Kirklees Council Planning & Development Service
PO Box B93, Civic Centre 3, Off Market Street, Huddersfield, HD1 2JR

Your reference: 2022/92711 and 121, Slaithwaite Road, Meltham, Holmfirth, HD9 5PW.

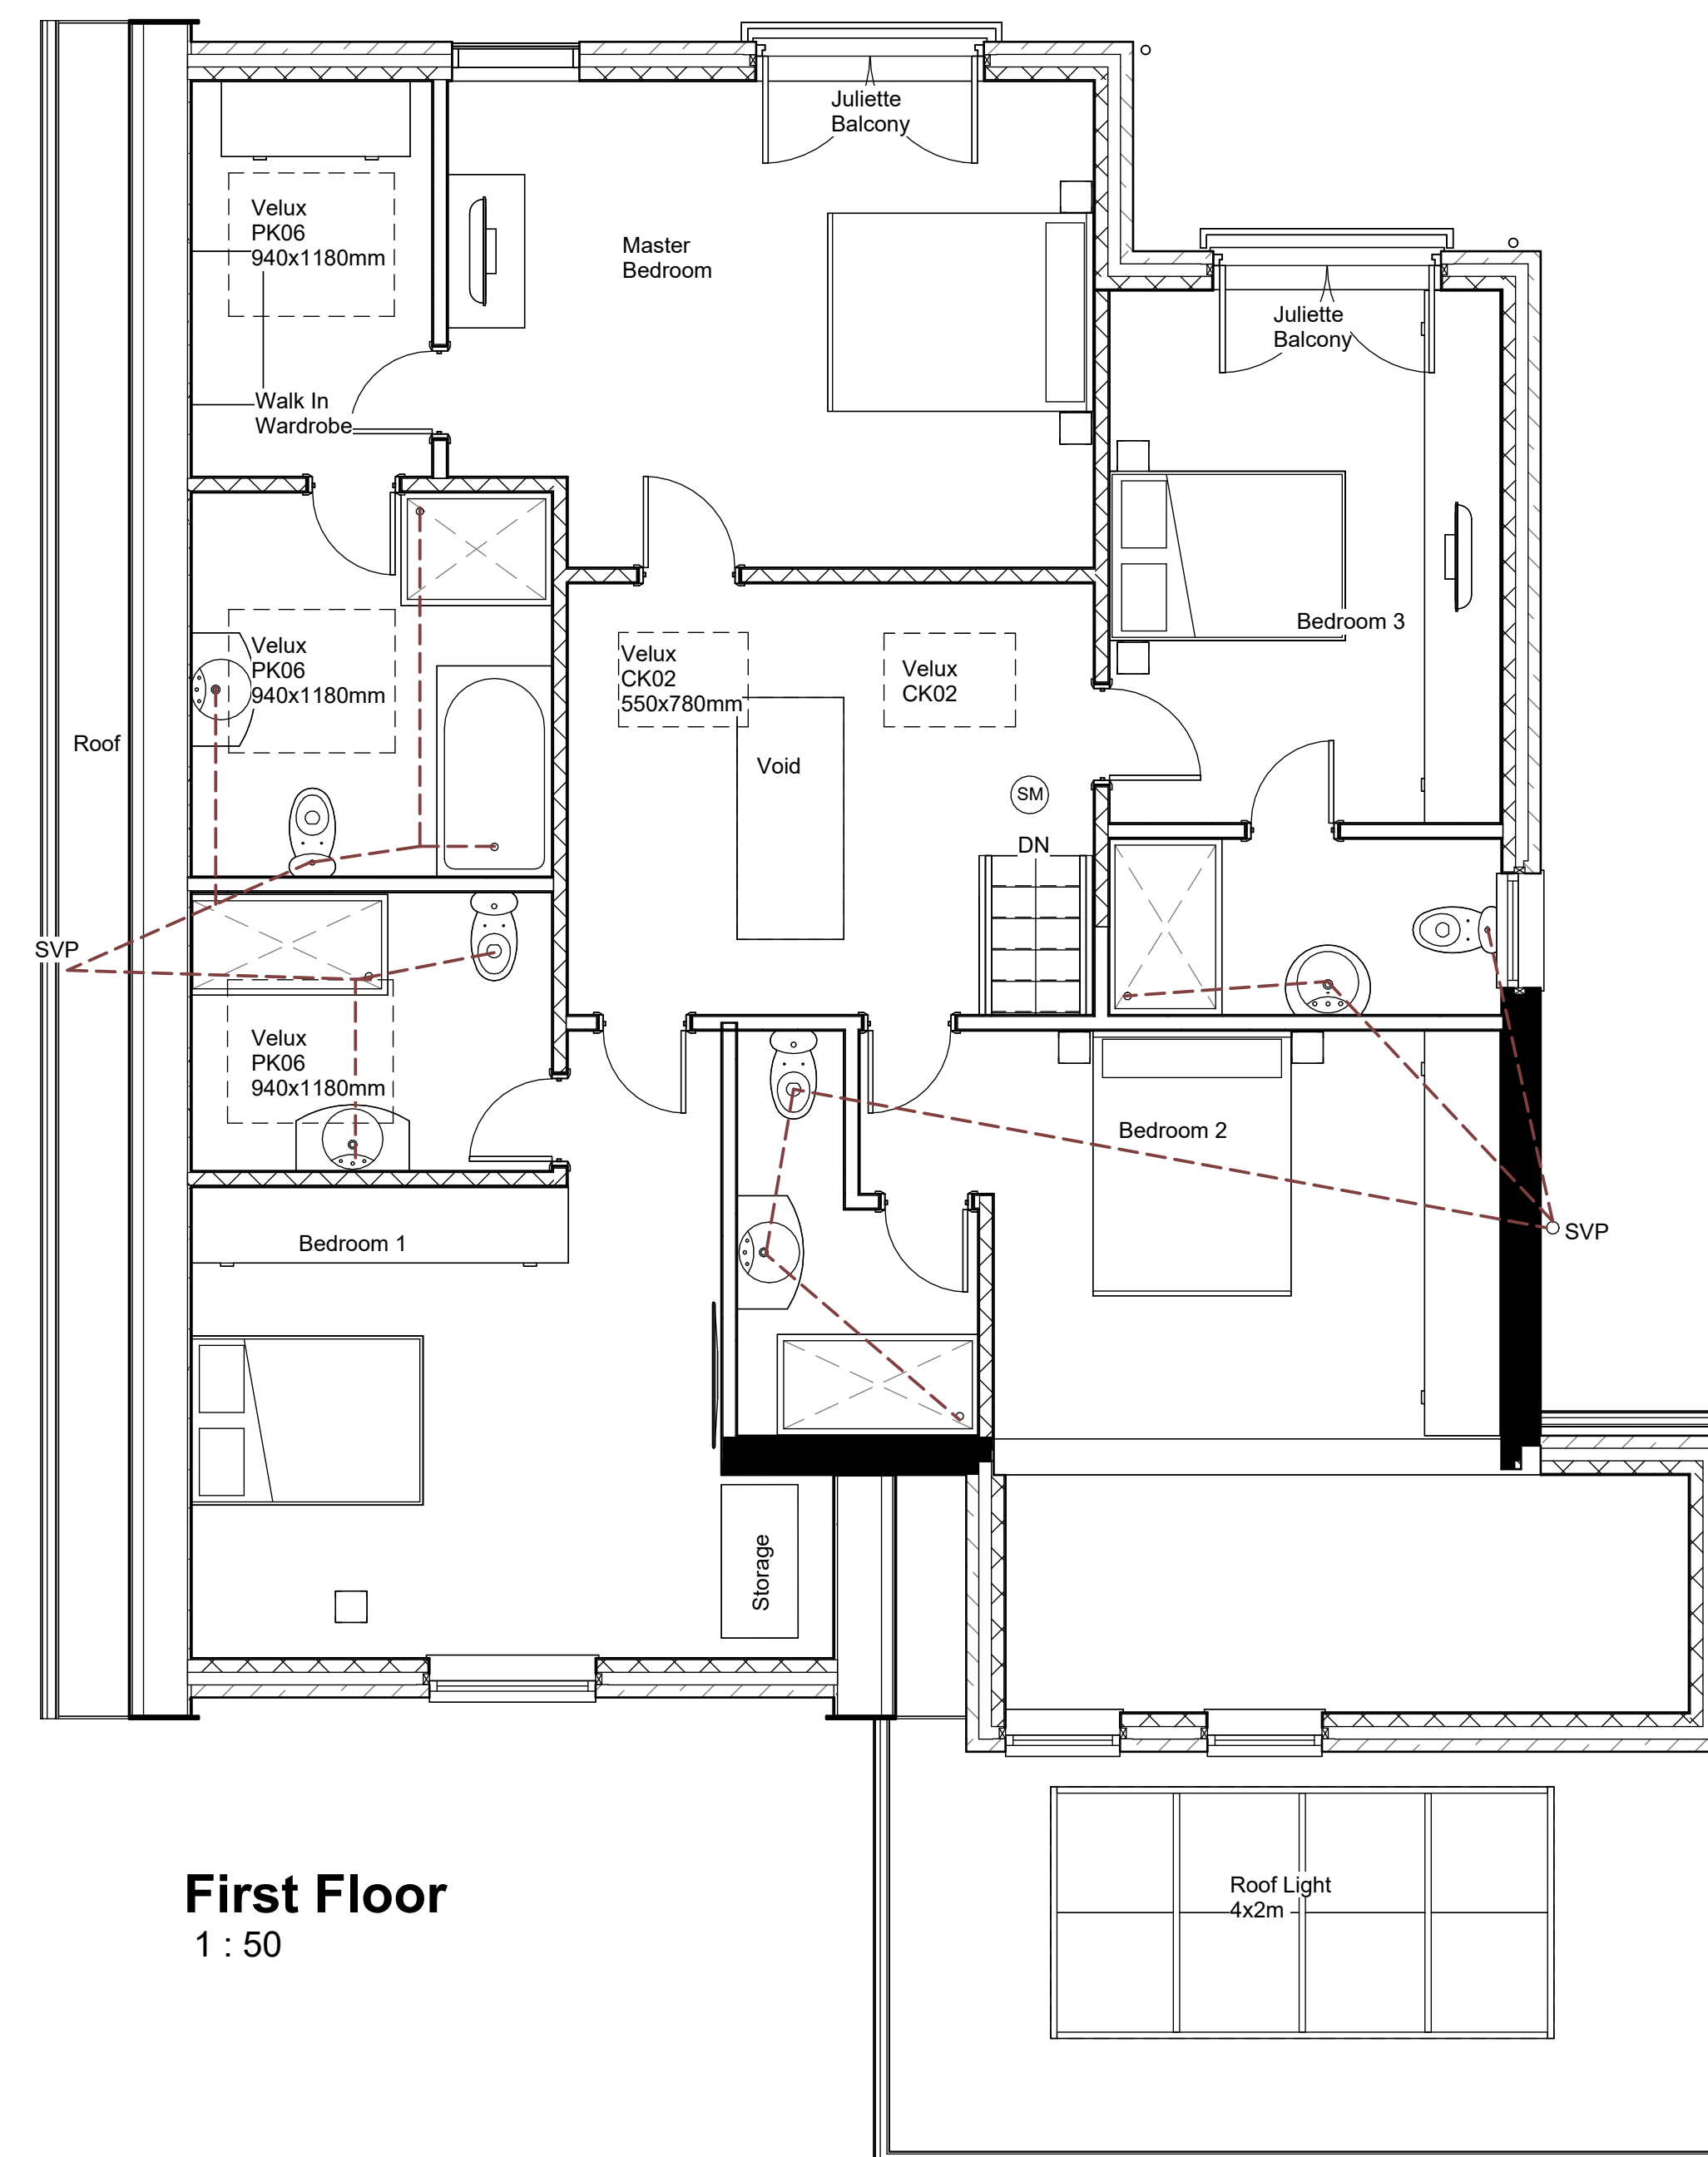
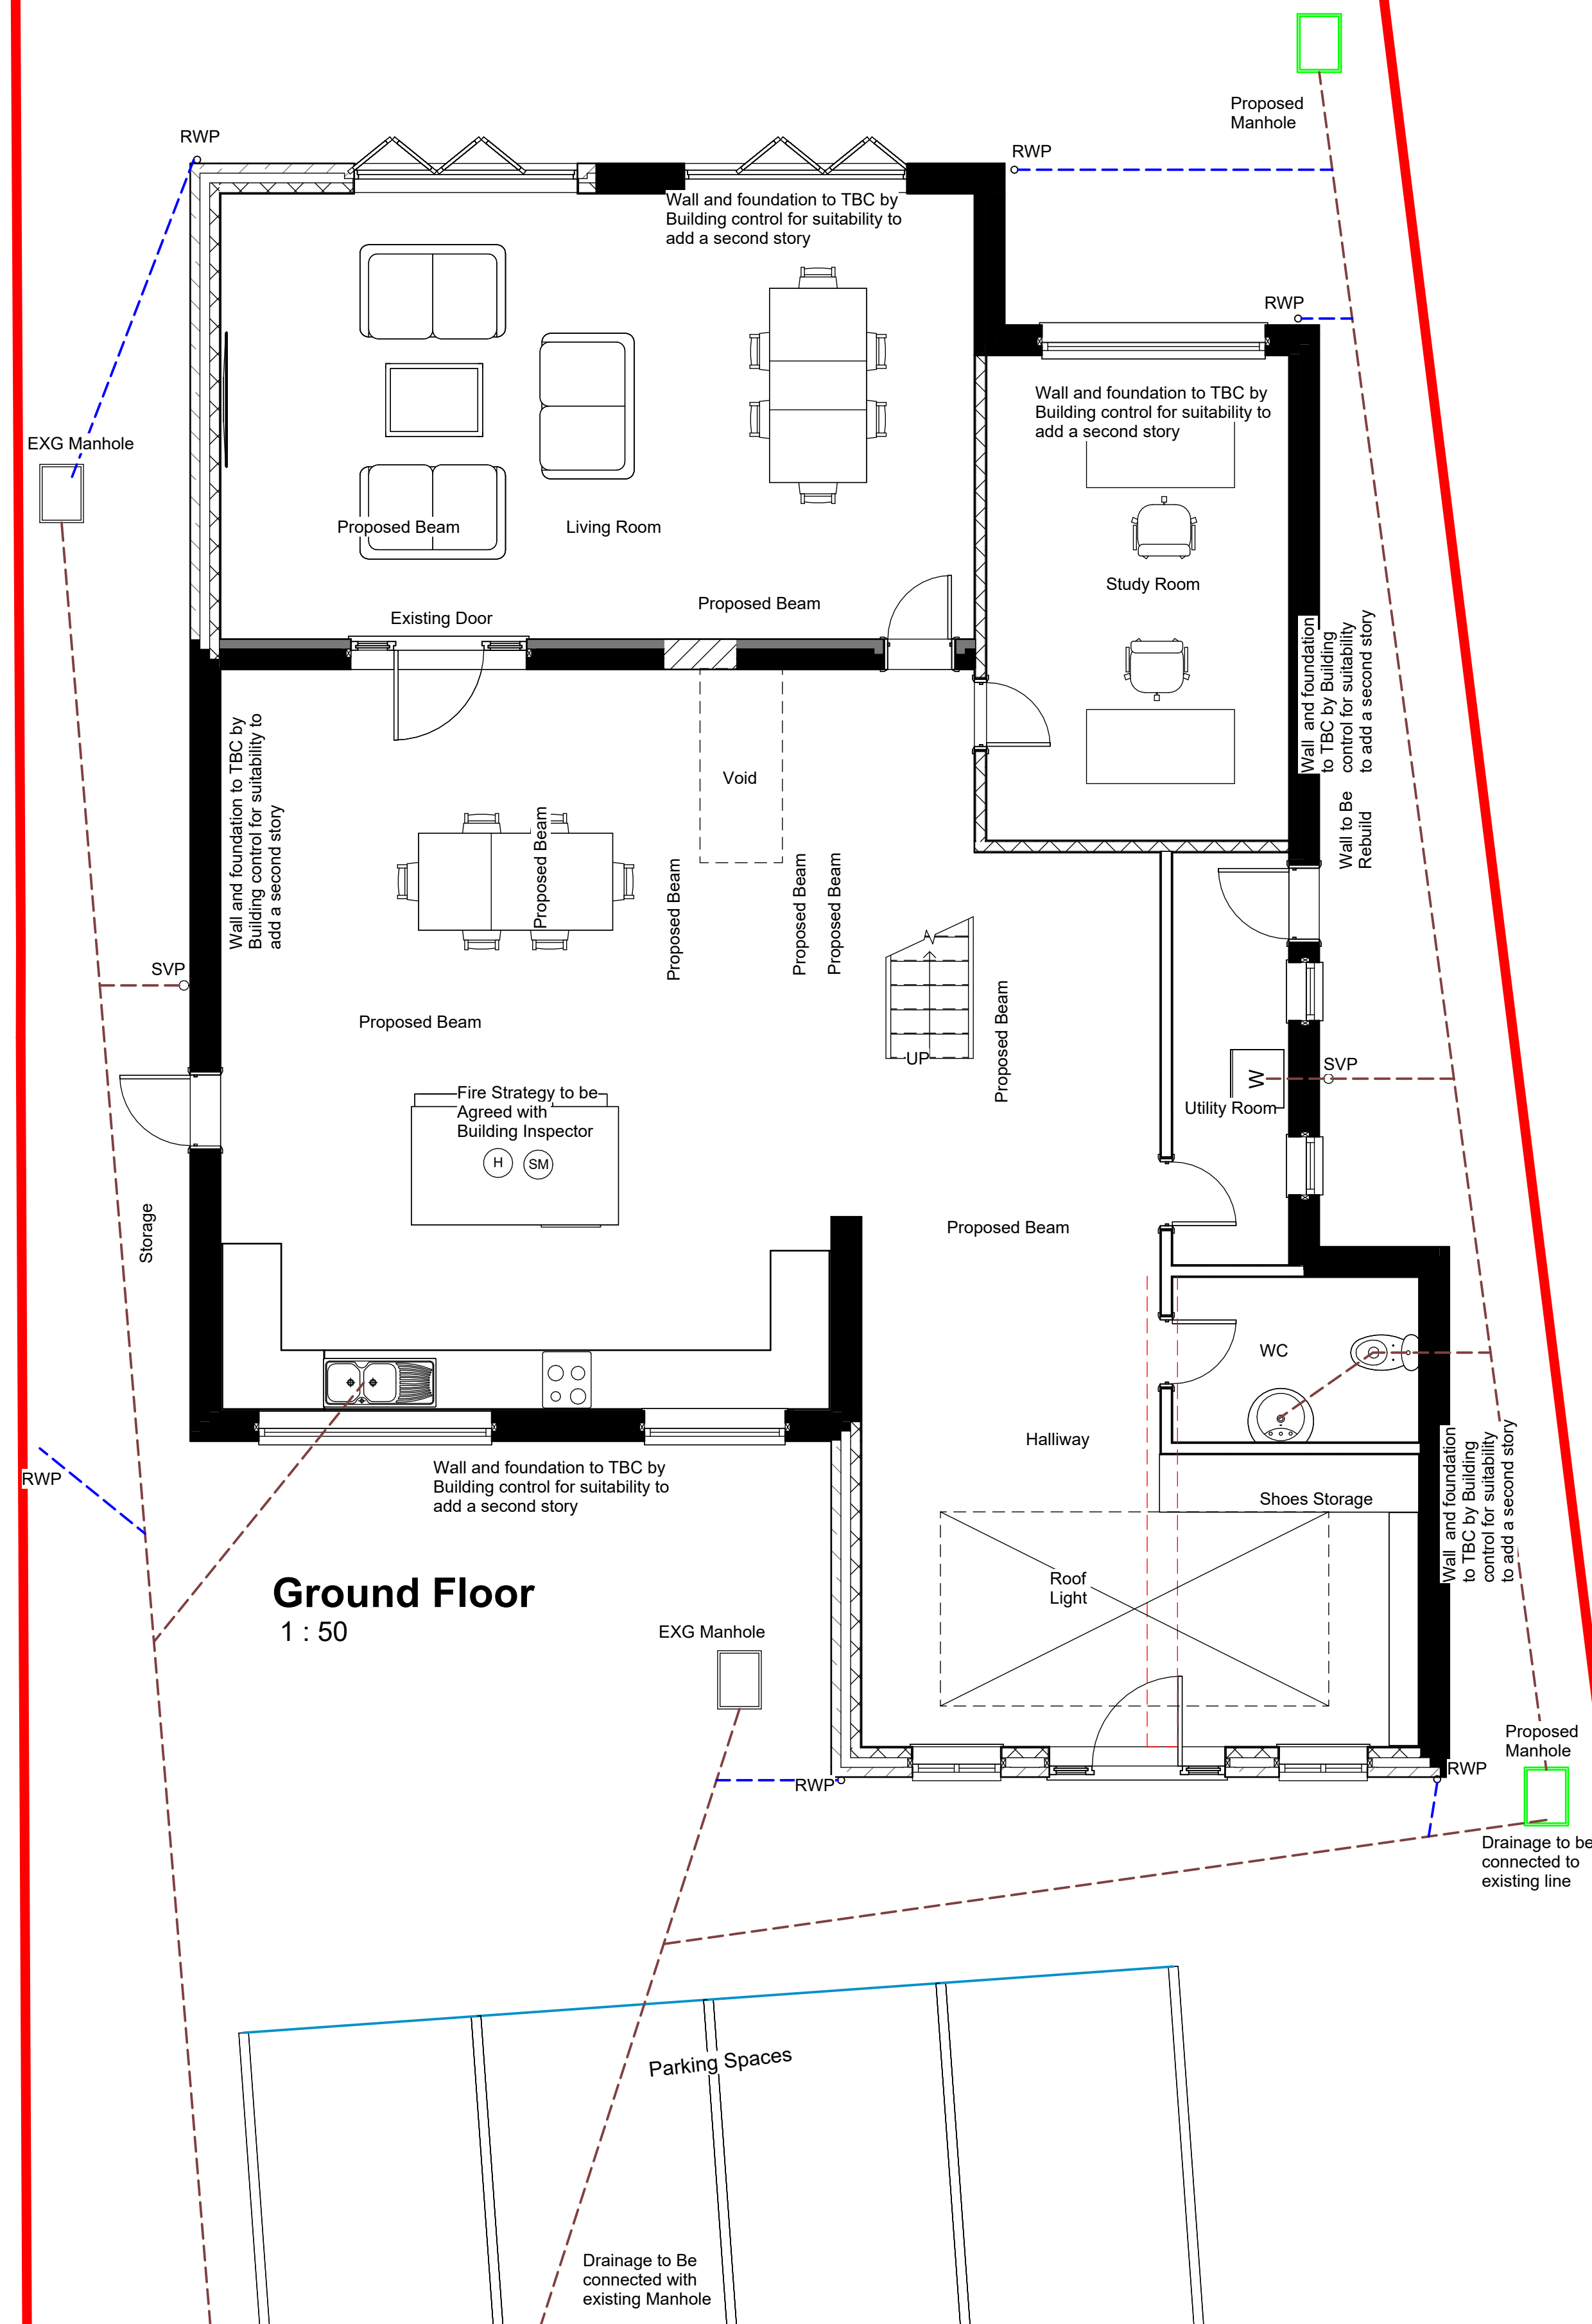
- 2) I am concerned at the increase in the height of the eaves relative to the original building at the address. The wall heights were to be increased by a metre from those existing before the proposed development. The wall height appears to have been increased further now, though by how much, is not annotated on the latest elevation plan (as it was on 2021/94239). I would wish to know please what the increase in proposed wall height is, when compared to the original? I have a real concern that the new wall height
will be great and that the increase in height over the
existing building will be unreasonable.

- 3) In comment too about that additional height of the walls, the roof pitch then has had to be lowered to what seems me, to be too low a slope. I begin to wonder if the roof is going to look more like that of a factory roof than that of a dwelling.

- 4) I refer here to the proposal to remove the garage structure and replace it with a double height hallway. I am not sure what effect the proposal will have on the aesthetic of the front of the property – it looks more than a little “clunky” to me from the elevation drawing – and I am concerned at the proposal for that reason. And so, to that end, I would still welcome a 3D view of the proposed elevations of the building. I note that one was provided with the first planning application 2021/93100 but not with the second nor with this third application.

- 5) I note the newly proposed (though now actual) increase in the depth of the windows on the first-floor rear elevation to the structure. As welcome as I am sure they are intended to be for an enhanced view of West Nab, I believe that both the proximity and elevation of No 121 relative to my house and garden will mean that the larger windows are now intrusive to my privacy.
